Application for a non-material amendment following a grant of planning permission.

Two storey rear/side extension involving demolition of existing garage and walkway and single storey detached garage to front

Reference number:	FP/192/19/HH
Date of decision	12/11/2019

0032-03A Proposed Plans
0032-06A Proposed Elevations

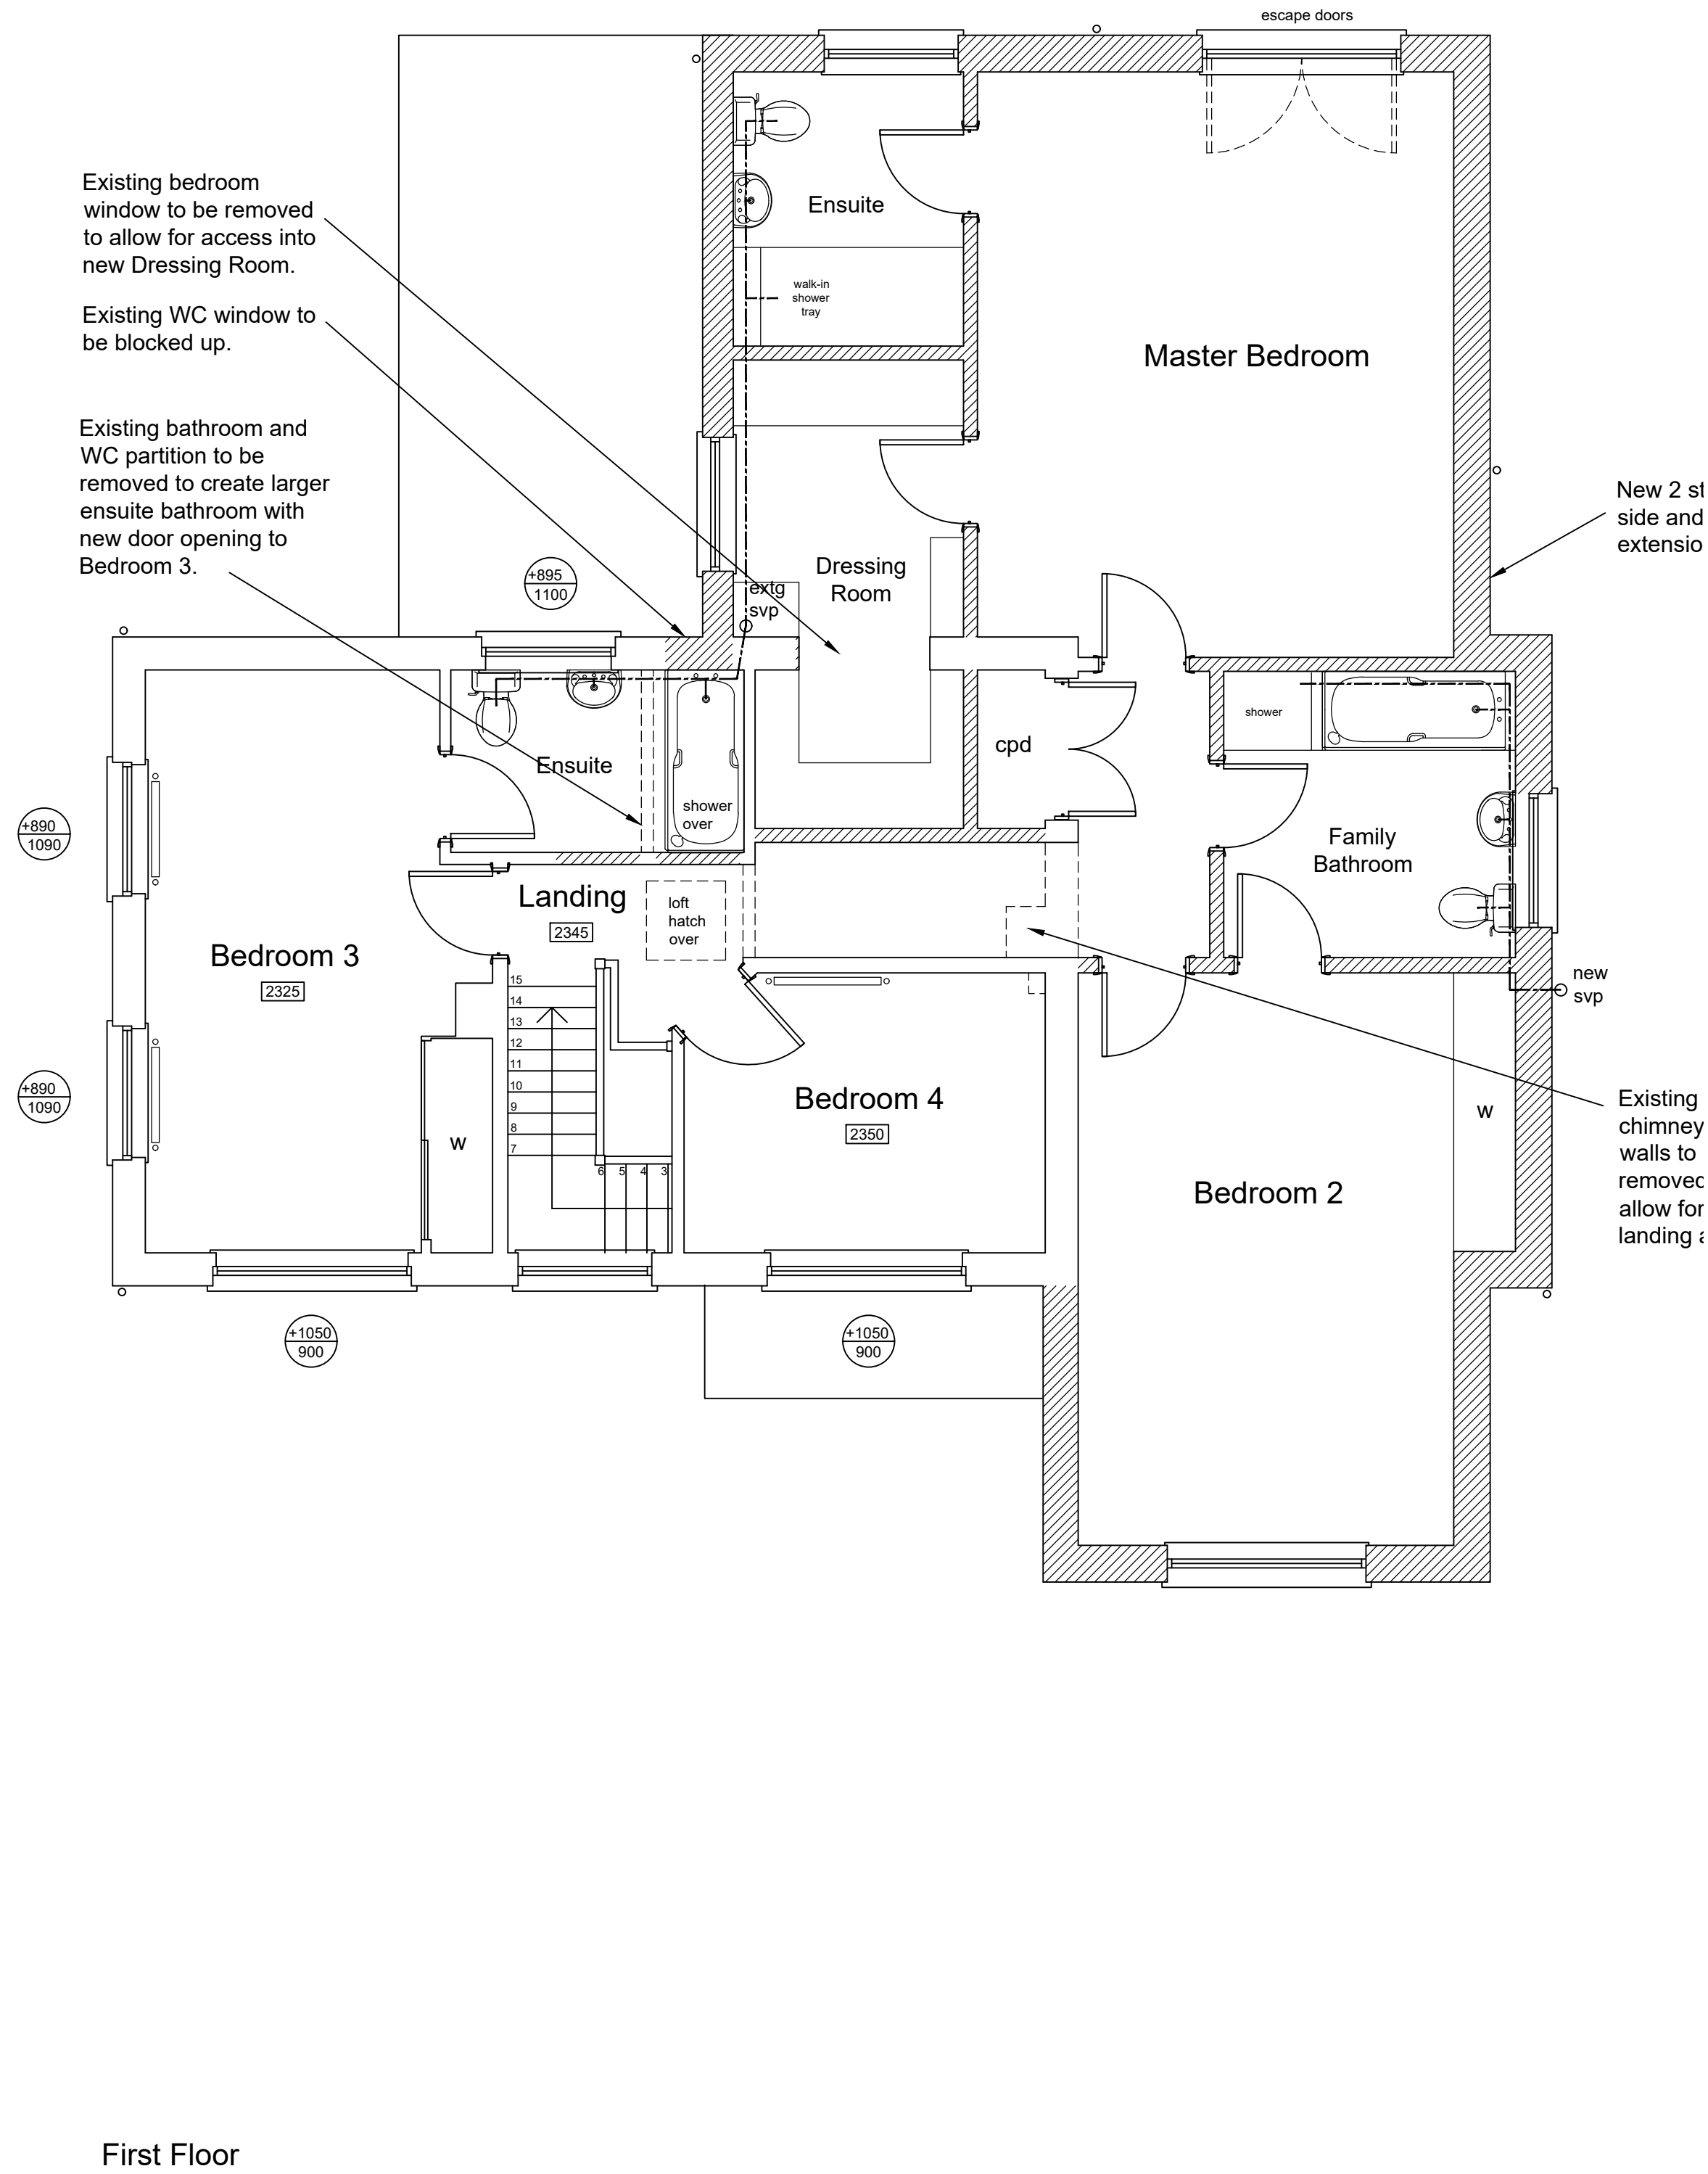
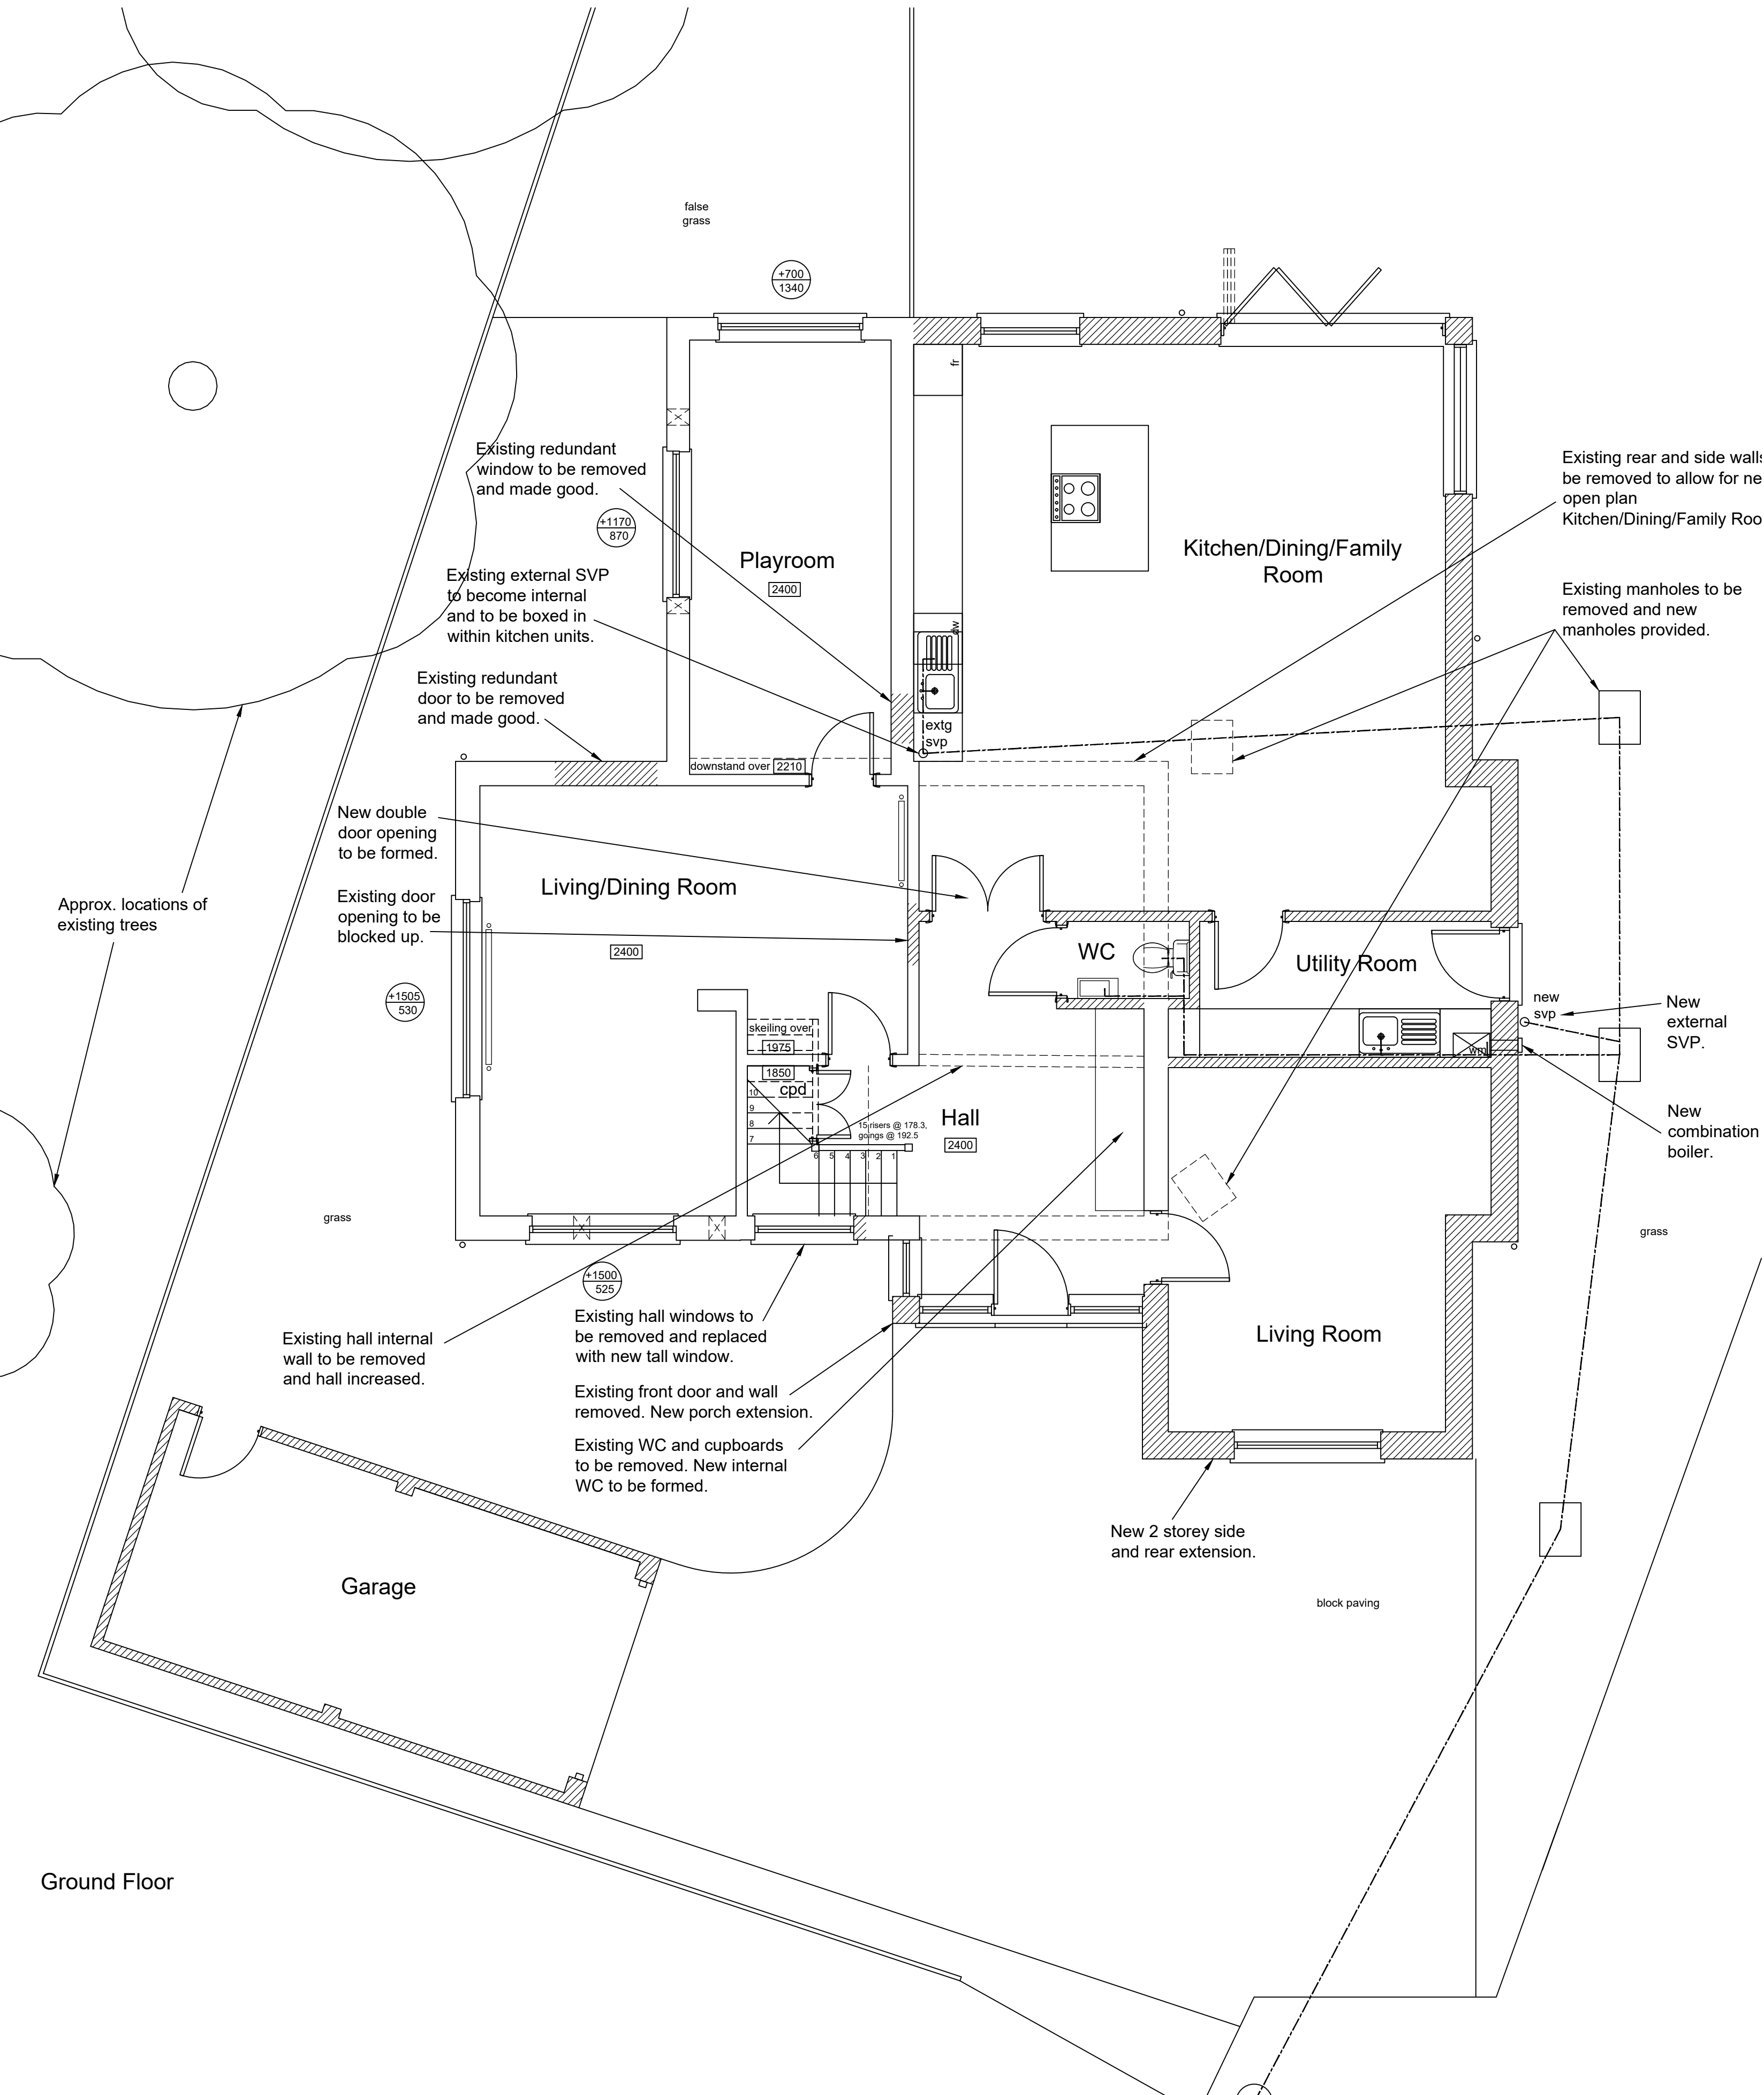
Addition of first floor Dressing Room obscured glazed window, only openable above 1.7m above finished floor level and alteration to Family Bathroom window to be obscured glazed and only openable above 1.7m above finished floor level.

The addition of the Dressing Room window is to provide daylight to the Dressing Room as it currently has no window.
The alteration to the Family Bathroom window is to accord with planning condition 3 of the current planning permission.

0032-03B Proposed Plans
0032-06B Proposed Elevations
